Application for a Non-Material Amendment Following a Grant of Planning Permission

Demolition of former care home and erection of 2 pairs of 2 storey, 4 bed, semi-detached dwellings (4 in total) to include habitable loft space, with associated parking, landscaping and refuse storage.

21/2185/FUL

Addition of 4no. obscure glazed non-openable windows to the side elevations of plots 2 & 3 respectively to match those approved on plots 1 & 4.

Drawing
**PLOTS 1 - 4
 PROPOSED GROUND & FIRST FLOOR**

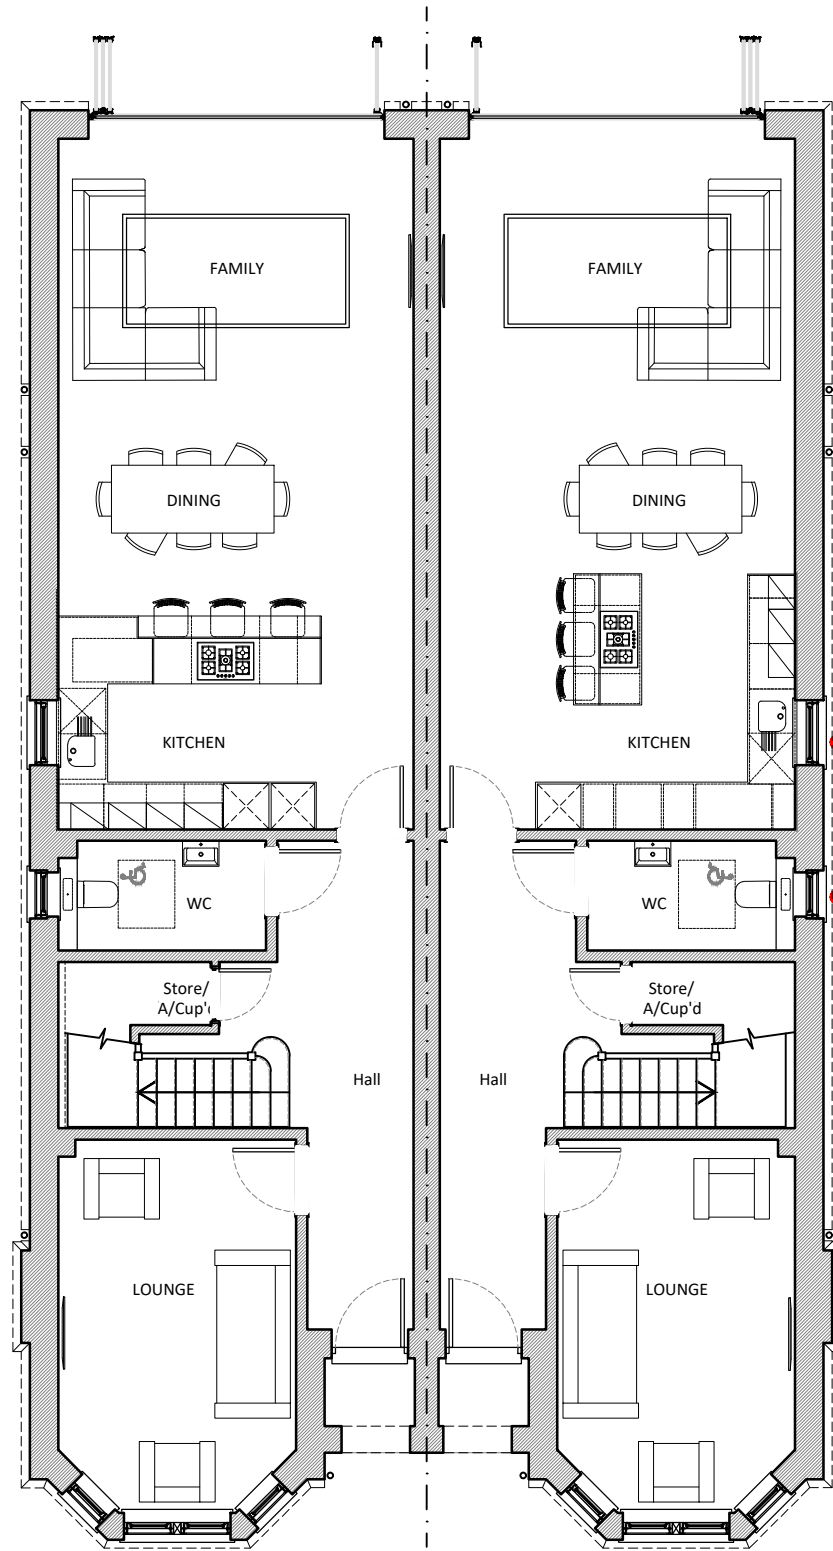
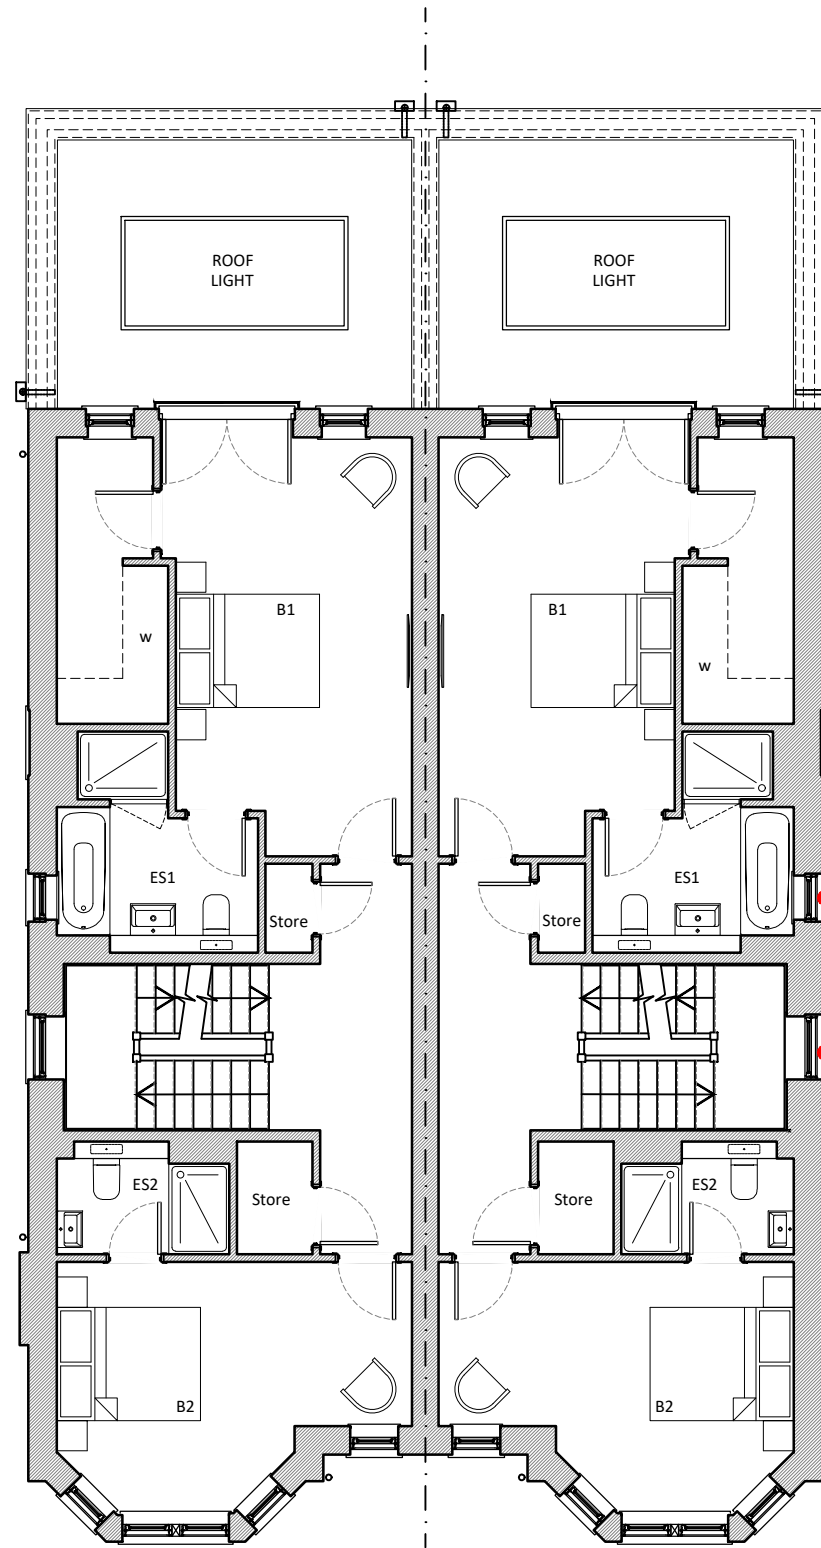
As approved, plots 2 & 3 have very limited natural light. The addition of the obscure glazed windows on the side elevations of plots 2 & 3 (to match those approved on plots 1 & 4) would notably improve the internal spaces and in doing so make for lighter, healthier and more energy efficient environments for the occupants.
